From: [REDACTED]
Sent: 16 December 2025 11:45
To: Susan Haley
Subject: Re: P/160/25/HH - 9 Well Road, Pagham
Attachments: 9, Well Road Planning Application Sheet 2b of 4 .pdf

Sheet 2 c of 4

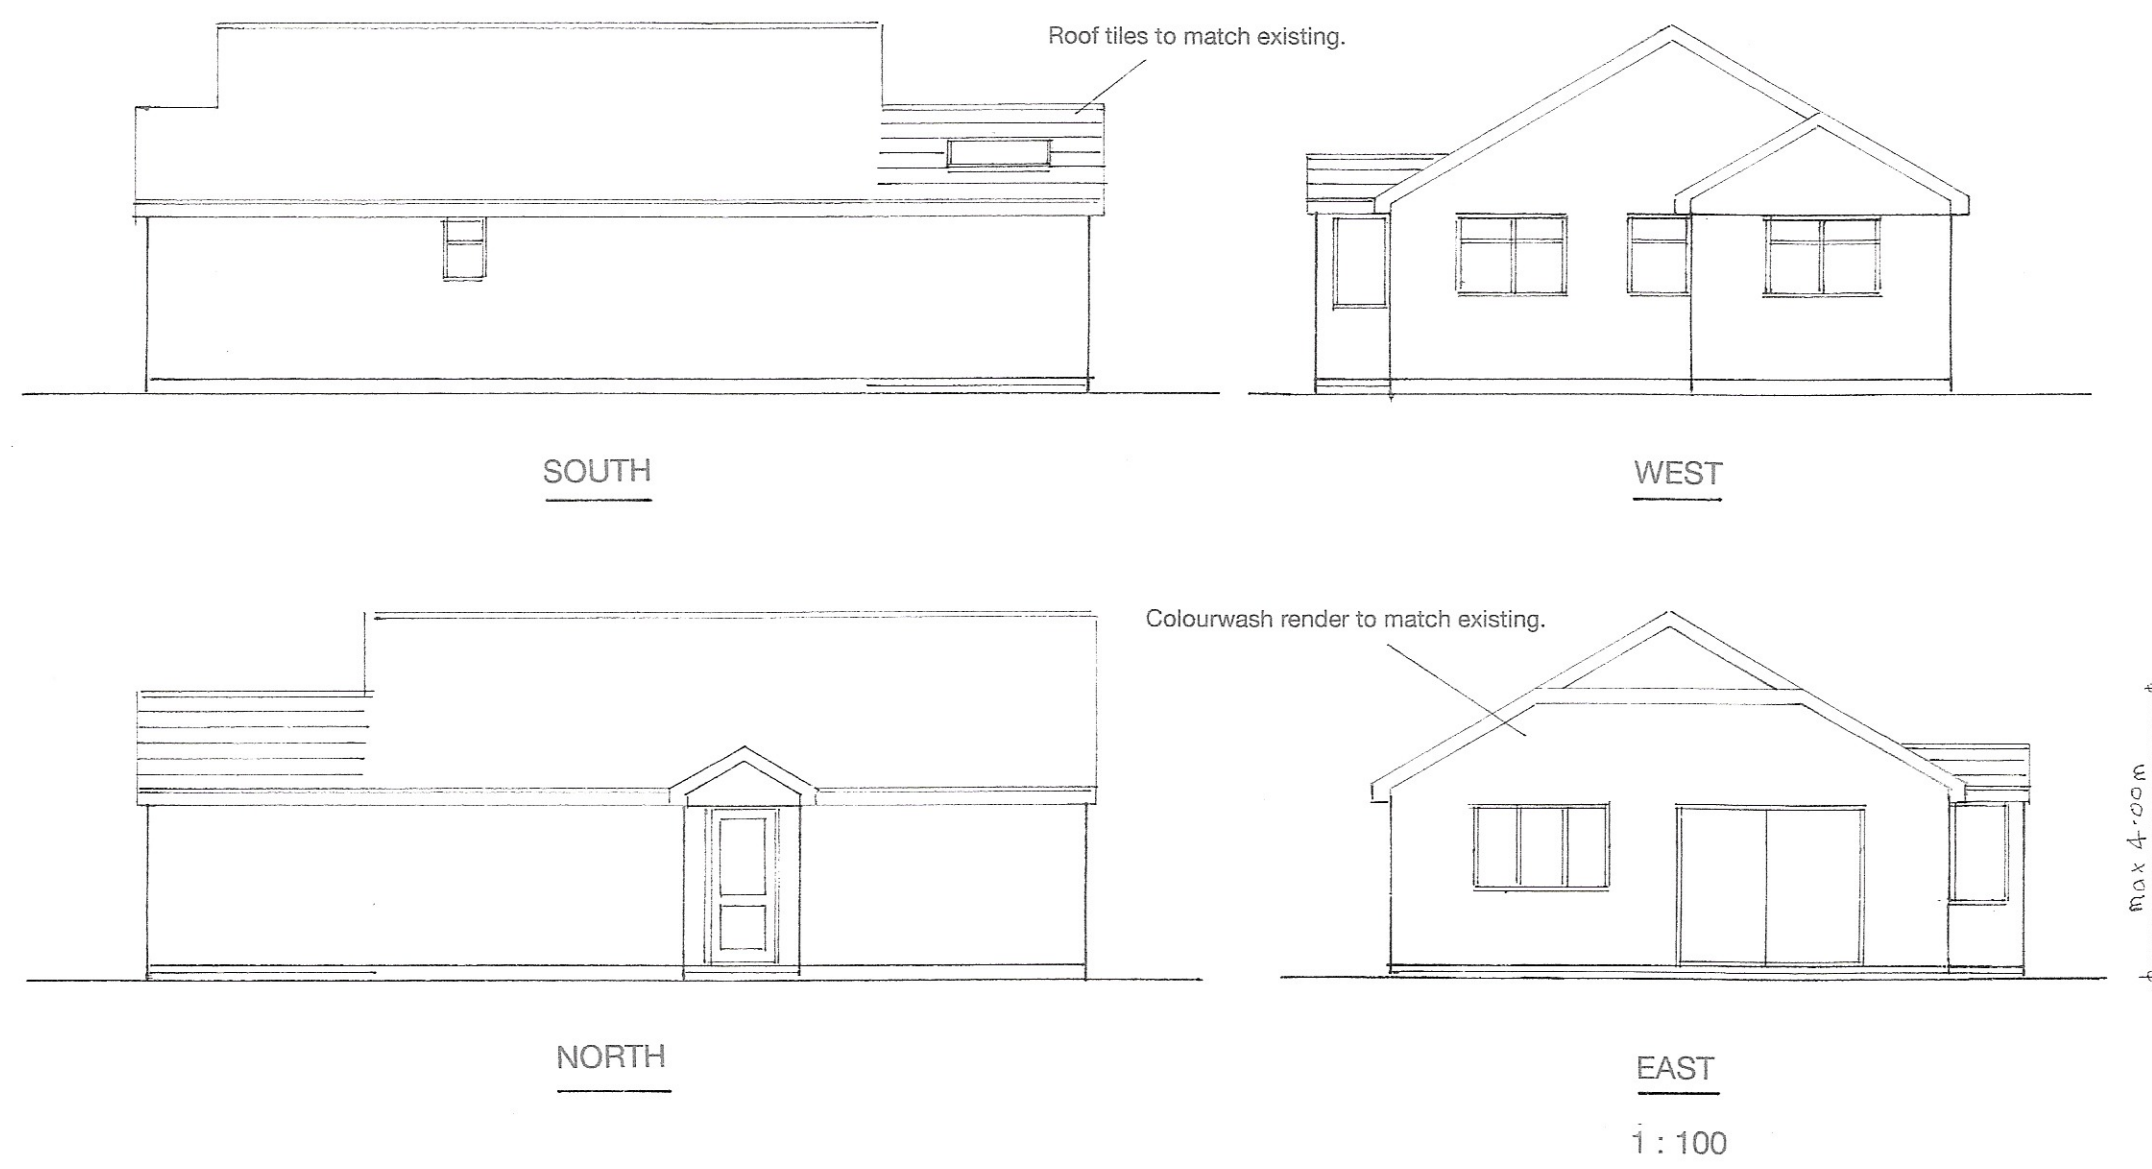
The ridge length you indicate on your 'red' marked plan is 3.00 metres the same as the extension's projection.

The max. 4.00 metres refers to the height of the extension and not the porch.

Sheet 2 a of 4

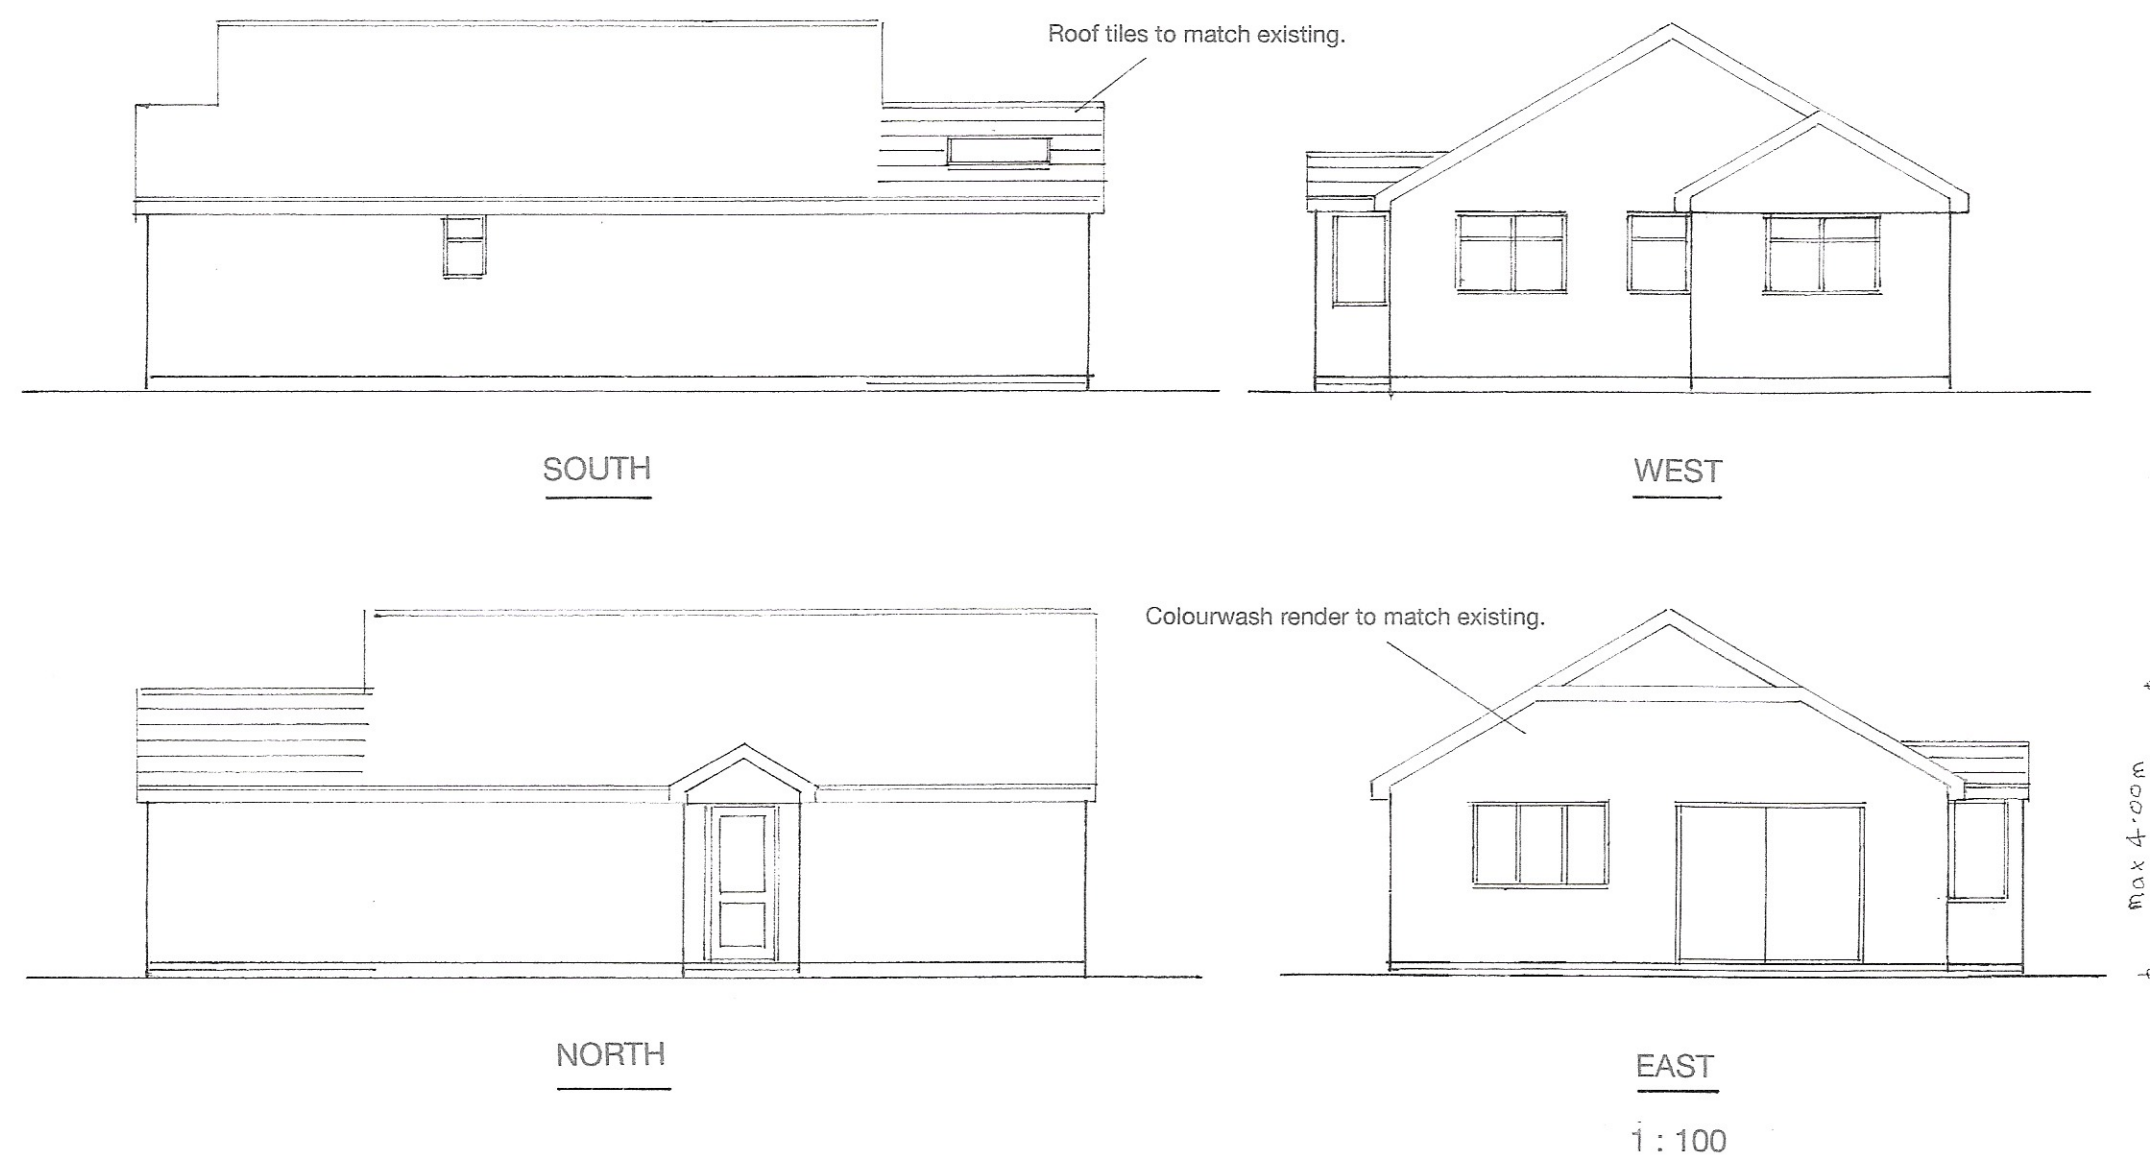
I have begun looking at application P/160/25/HH and noticed that the plan 'Sheet 2a of 4' was not scaling as per the scale stated. Please could you check if the plans have been saved in a format that our software can measure and also add a scale for each of the sections. I have attached a copy to show you what I am referring to.

Apologies for the lack of scale on the plan which I have now added.
